| Application number: 2024/90923   |                                                                                  |
| What is the application for?:    | Demolition of existing conservatory and erection of single storey side extension |
| Address of the site or building: | Kelvin Villa, 1, Newsome Street, Dewsbury, WF13 4HE                              |

PROPOSED FRONT ELEVATION
1:100 @ A1

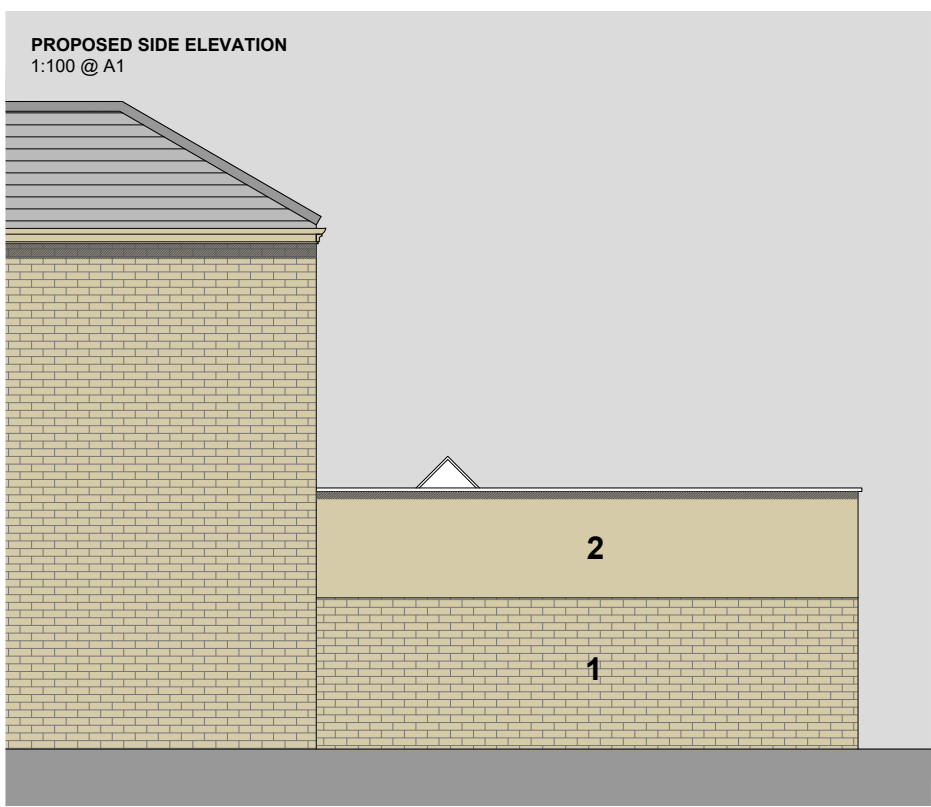
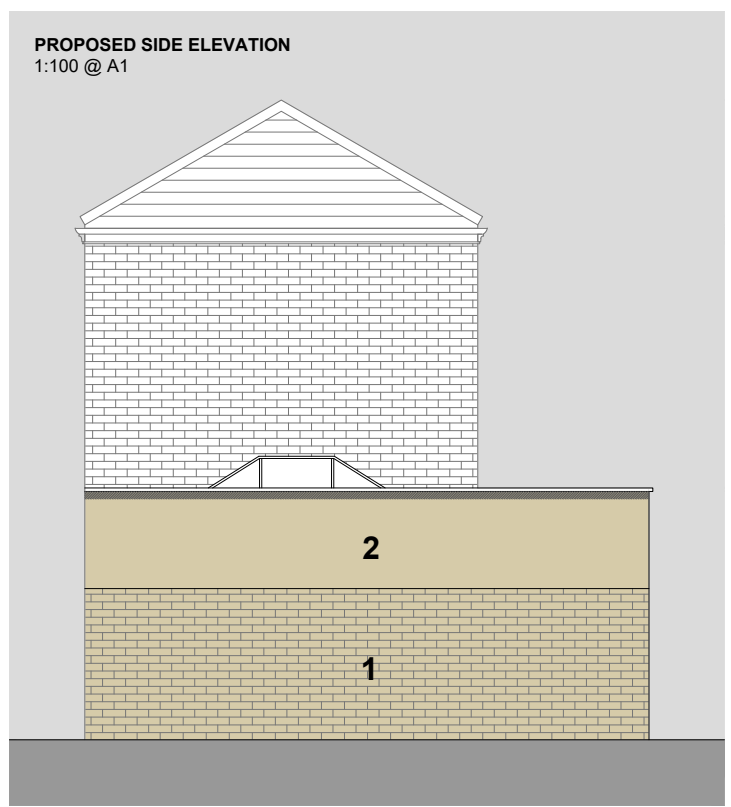
As mentioned above plus with the link provided which shows pictures on how the conservatory looked prior the unauthorised single story side extension it should be built the same as it was before, matching brick work which has to match the current house and no use of rendering.

The new single storey extension must not be taller and bulkier extension in overall terms, with its front and side elevations much higher than those of the previous structures. As such, it looks a much larger and bulkier extension and, unlike the incremental additions to the property that it replaced, its width relative to that of the main house gives it a more dominant presence at the side of the house. In this sense, the extension fails to read as a subservient addition to the property and is in congruously unsympathetic to the scale, character and appearance of the main house.
